CITY OF ALBUQUERQUE

July 7, 2005

**Re: Office Building Facility, 800 Lomas Blvd. NW, Grading & Drainage Plan
Engineer's Stamp dated 6-17-05 (J14-D94)**

GRADING & DRAINAGE PLAN

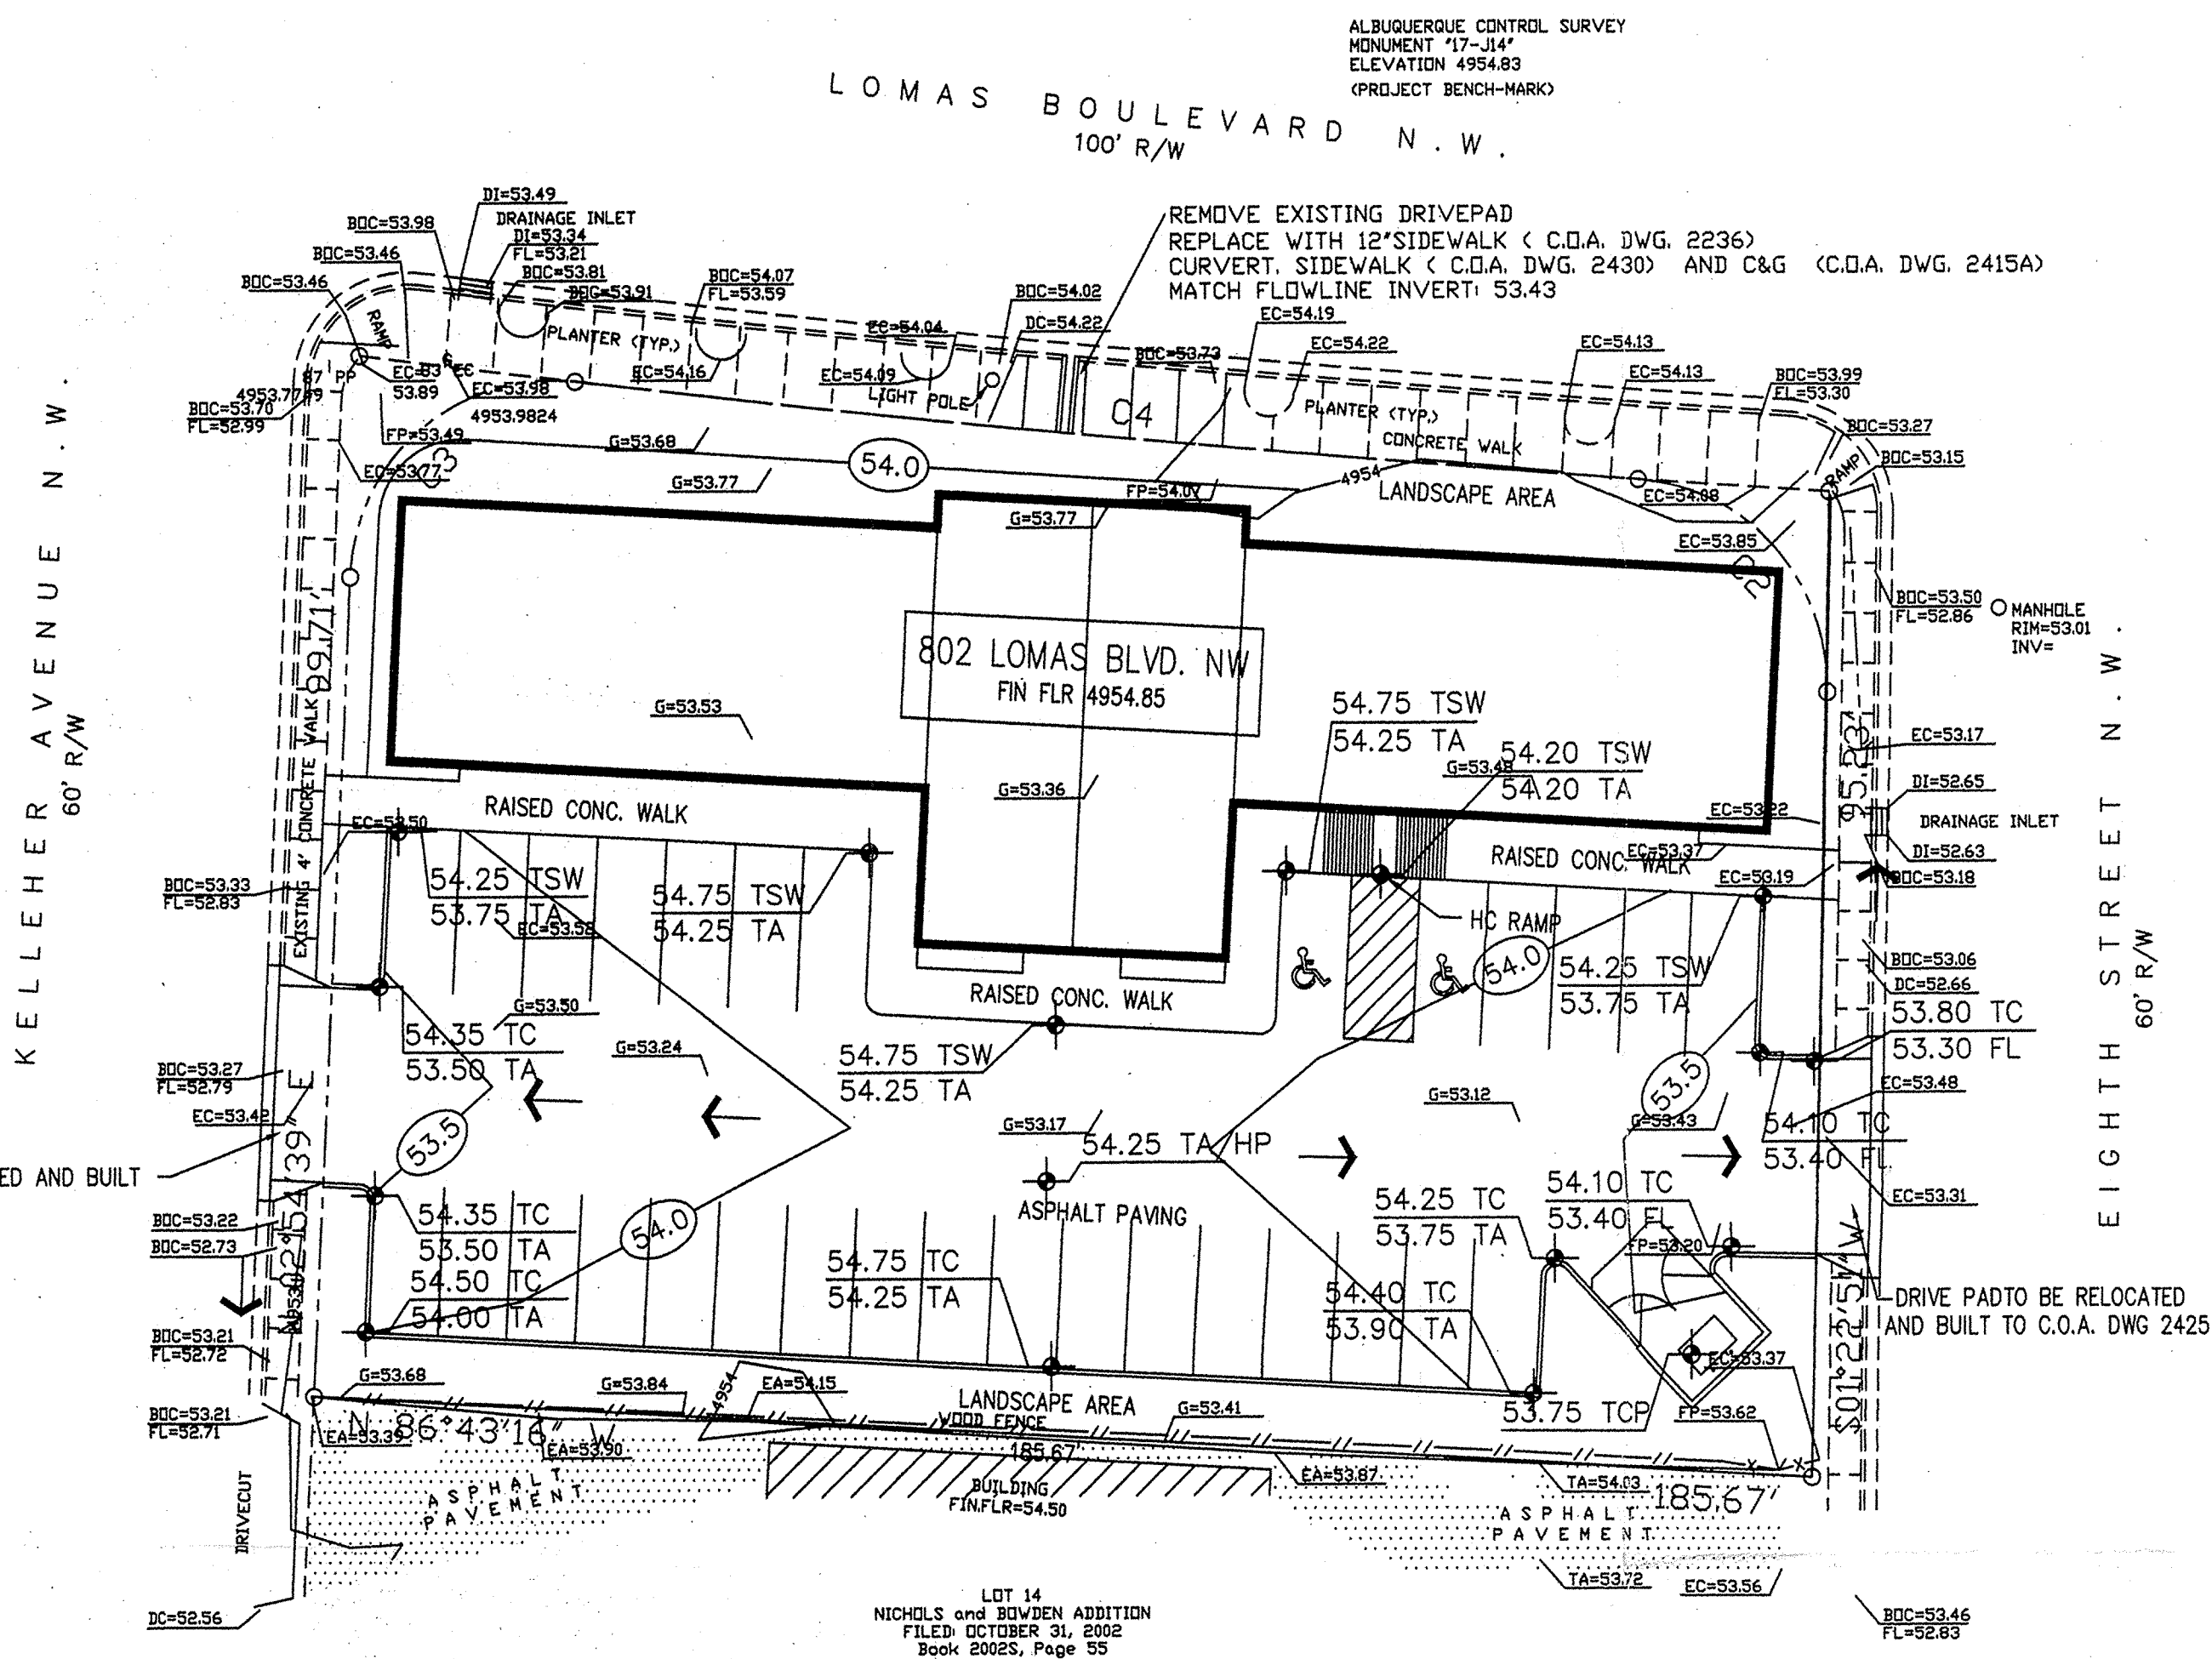
- Provide inverts for the proposed sidewalk culvert. ✓
- Call out City of Albuquerque Standard Drawings for the proposed sidewalk ✓ culvert, sidewalk and curb and gutter.
- Verify flow direction along Kelleher Avenue. ✓
